Marine  
Management  
Organisation

MMO Reference: DCO/2019/00005  
Planning Inspectorate Reference: EN010117  
Registration Identification Reference:20045232

**Planning Act 2008, E.On Climate and Renewables UK Ltd, Proposed Rampion 2 Offshore Wind Farm Order**

#### Deadline 6

Figure 6– INSPIRE Light Noise modelling for 141 dB SEL pile strike, with various mitigations

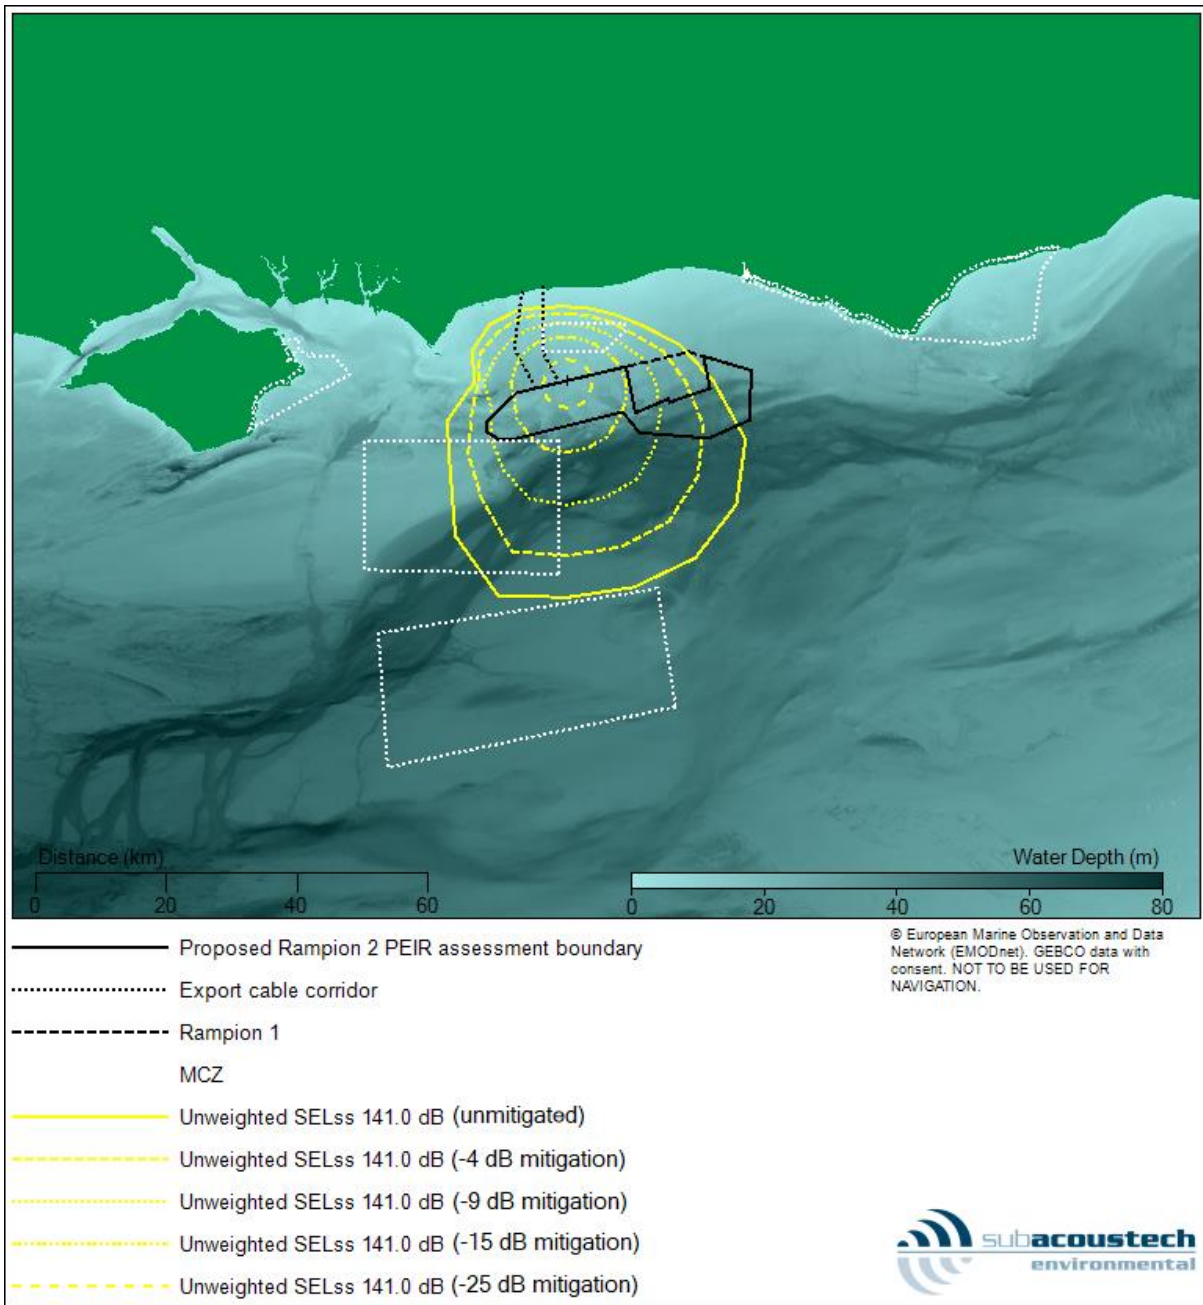
<p>Black sea bream UWN disturbance threshold</p>	<p>A threshold approach has been based on a threshold of 141dB re 1µPa SELss as defined by Kastelein et al., (2017). This has</p>	<p>MMO does not consider a SELss of 141 dB re 1 mPa<sup>2</sup> s used for a 44cm captive seabass to be an appropriate or conservative threshold.</p>	<p>This is still outstanding and the MMO considers this a material issue.</p>

<p>also been used to form the basis of mitigation.</p> <p>The MMO maintain that a behavioural noise threshold of 135 dB is required to protect sensitive features against underwater noise impacts associated with the project.</p> <p>The MMO believes this a fundamental disagreement and no progress forward has been made.</p> <p>Please see Sections 5.7 and 8.1 of our DL6 response.</p>	<p>MMO understands there was no agreement between MMO, Natural England (NE) and the Applicant on a noise threshold or proxy species for black sea bream prior to submission of the Application. The MMO acknowledges the Applicant's provision of additional modelling based on the MMO preferred threshold of 135 dB but acknowledge there is yet to be an agreed threshold between MMO, NE and the Applicant.</p> <p>Agreement will be depended on the provision of information to confirm that proposed noise abatement technologies will be able to achieve the noise reductions indicated by the Applicant.</p> <p>Although information has been provided by the Applicant further updates are still required.</p>

**Figure 5-6 Mitigated monopile piling impact contours (141dB re 1  $\mu$ Pa<sup>2</sup>s (SELss)) used to define piling exclusion zones (PULSE hammer mitigation and DBBC (22dB reduction))**

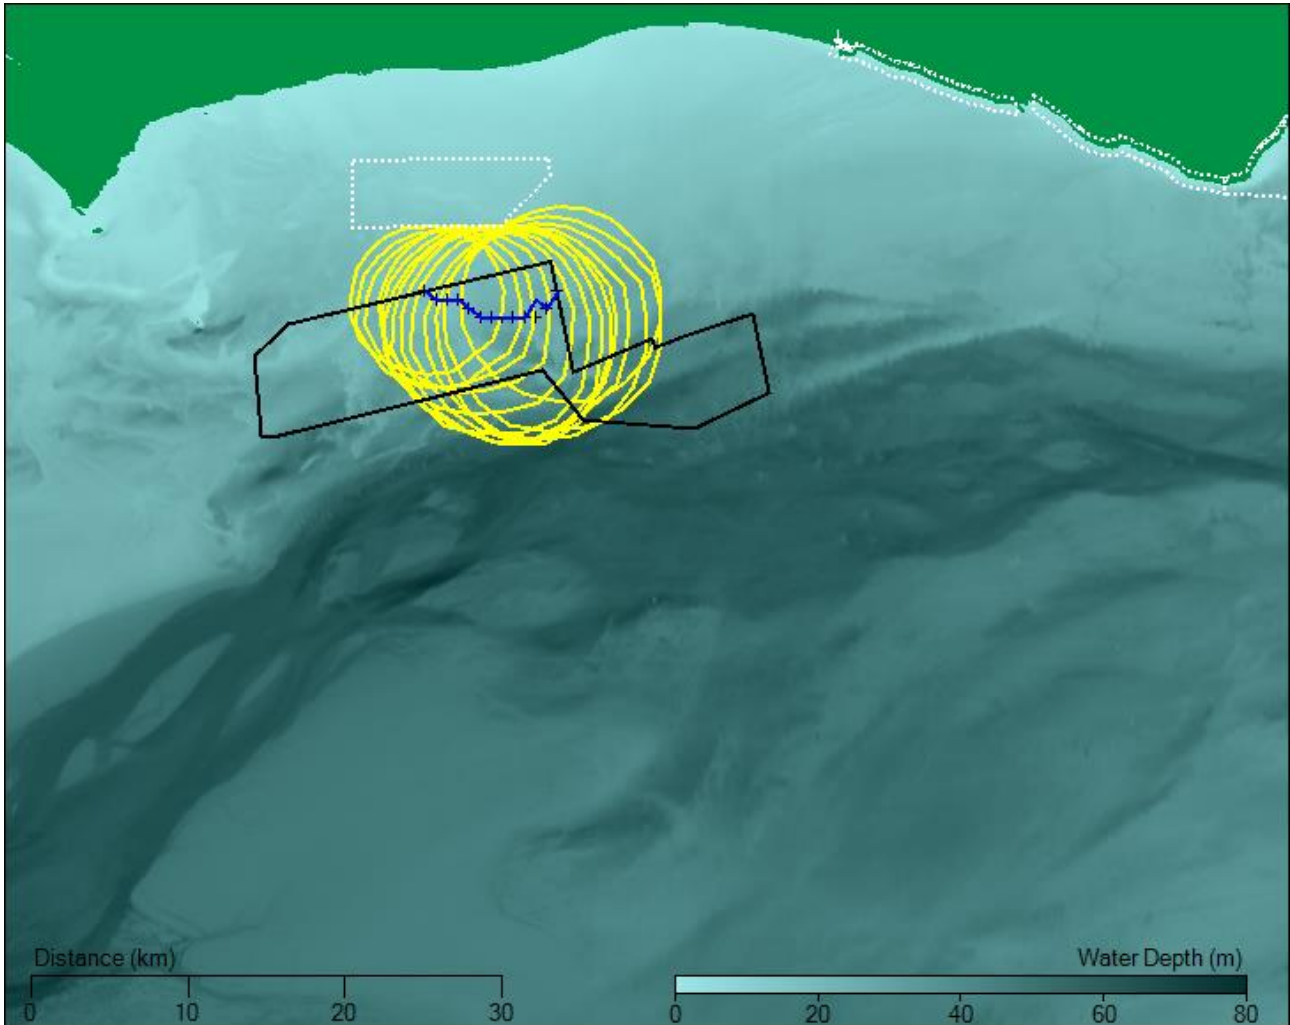
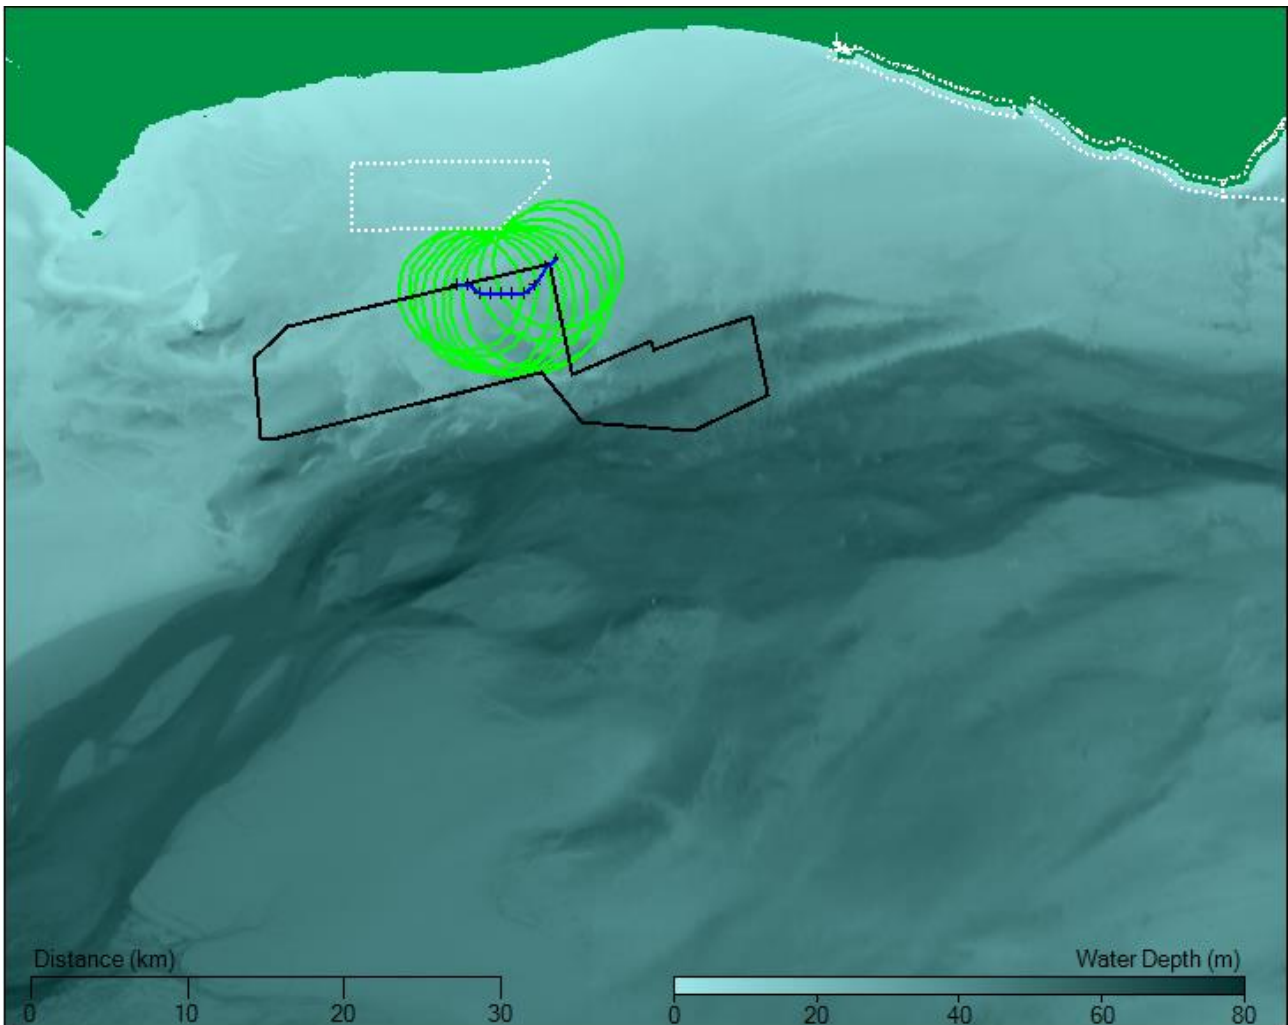
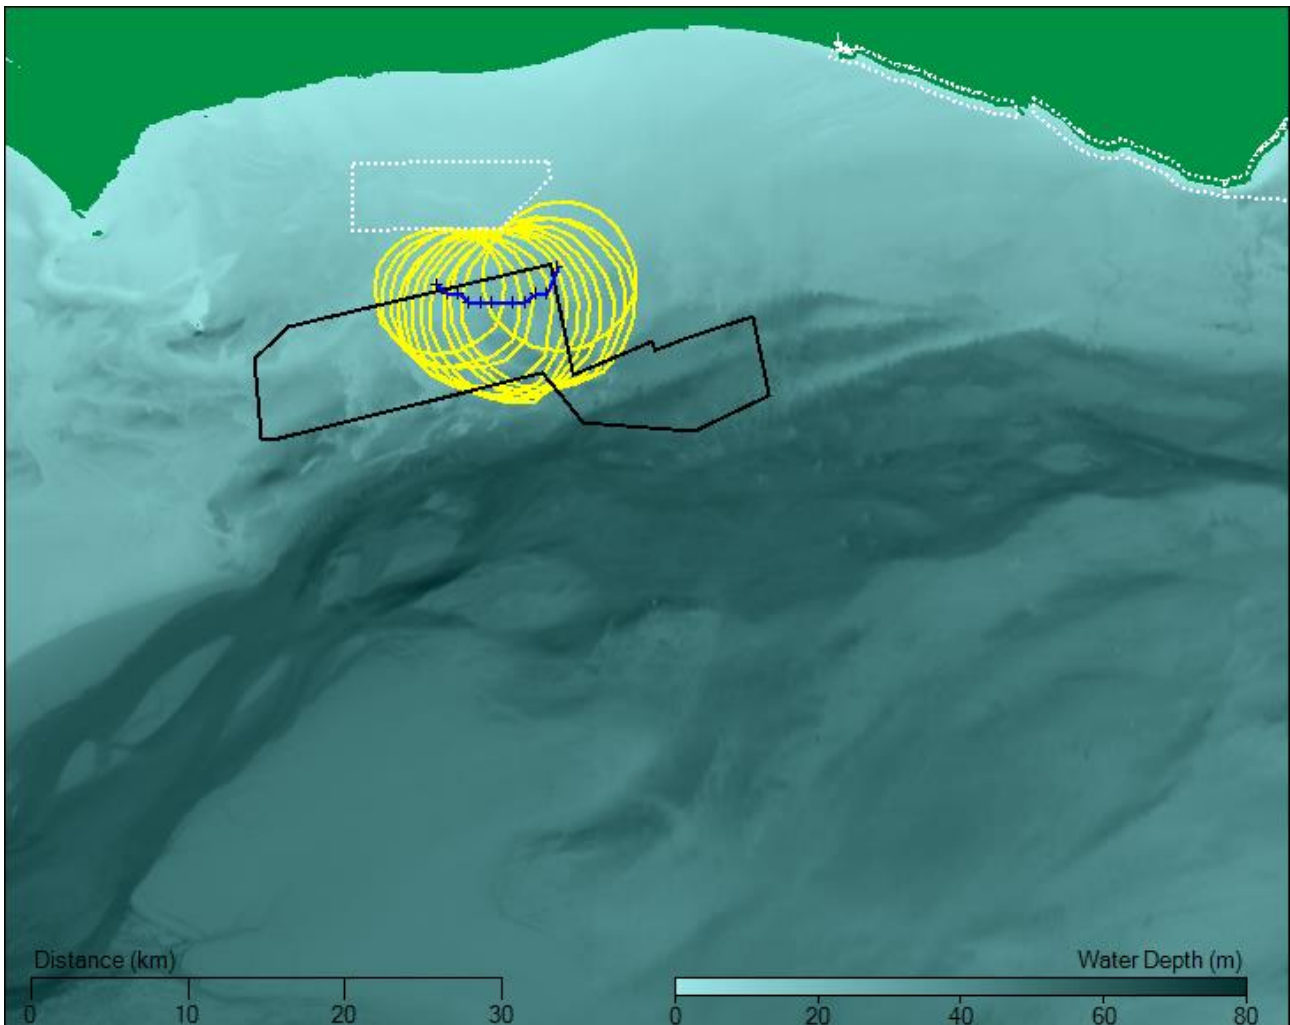
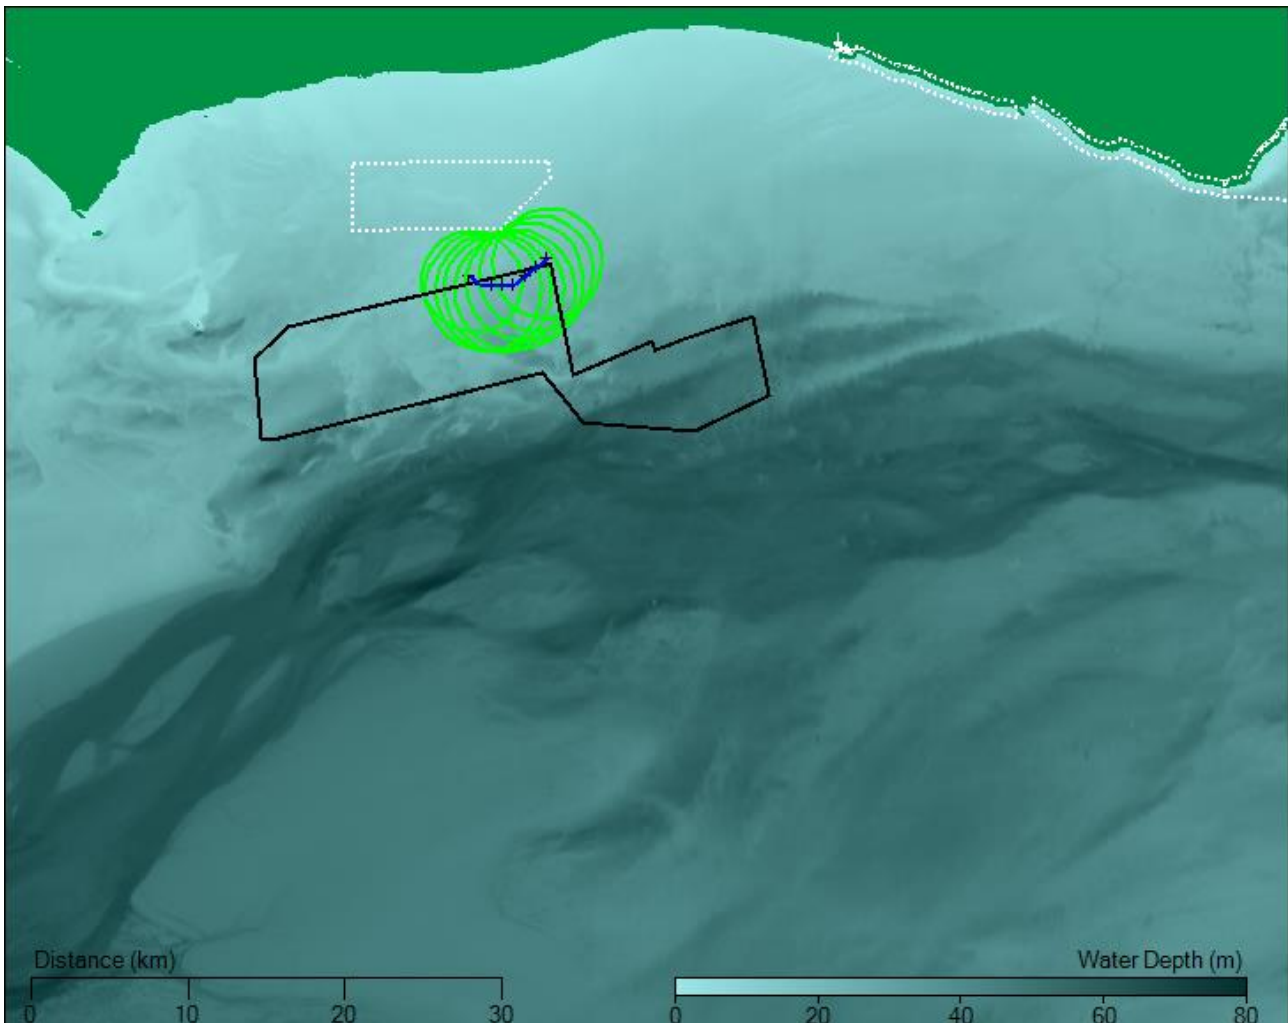
should be expected relative to sensitive features. e MMO hasve also not seen UWN modelling showing the mitigated UWN contours for a 13dB, 14dB and 15dB noise abatement reduction compared to each other.		
Appendix 8.3 Underwater noise study for sea bream disturbance, August 2023.	<p>The MMO agrees that the use of proxy species may be suitable (use of the audiogram for red seabream as a proxy for black seabream in terms of hearing ability), but requires:</p> <p>b) further (longer term) evidence for the baseline soundscape at Kingmere MCZ</p> <p>While the MMO is satisfied with the underwater noise monitoring data provided, the MMO does not agree with the use of seabass as a proxy species and the 141db threshold used in this report.</p>	<p>DL6: The Applicant has provided some information. However, this does not alleviate the concerns raised.</p> <p>Please see Sections 5.7 and 8.1 XX of our DL6 response.</p>	This is still outstanding and the MMO considers this a material issue.
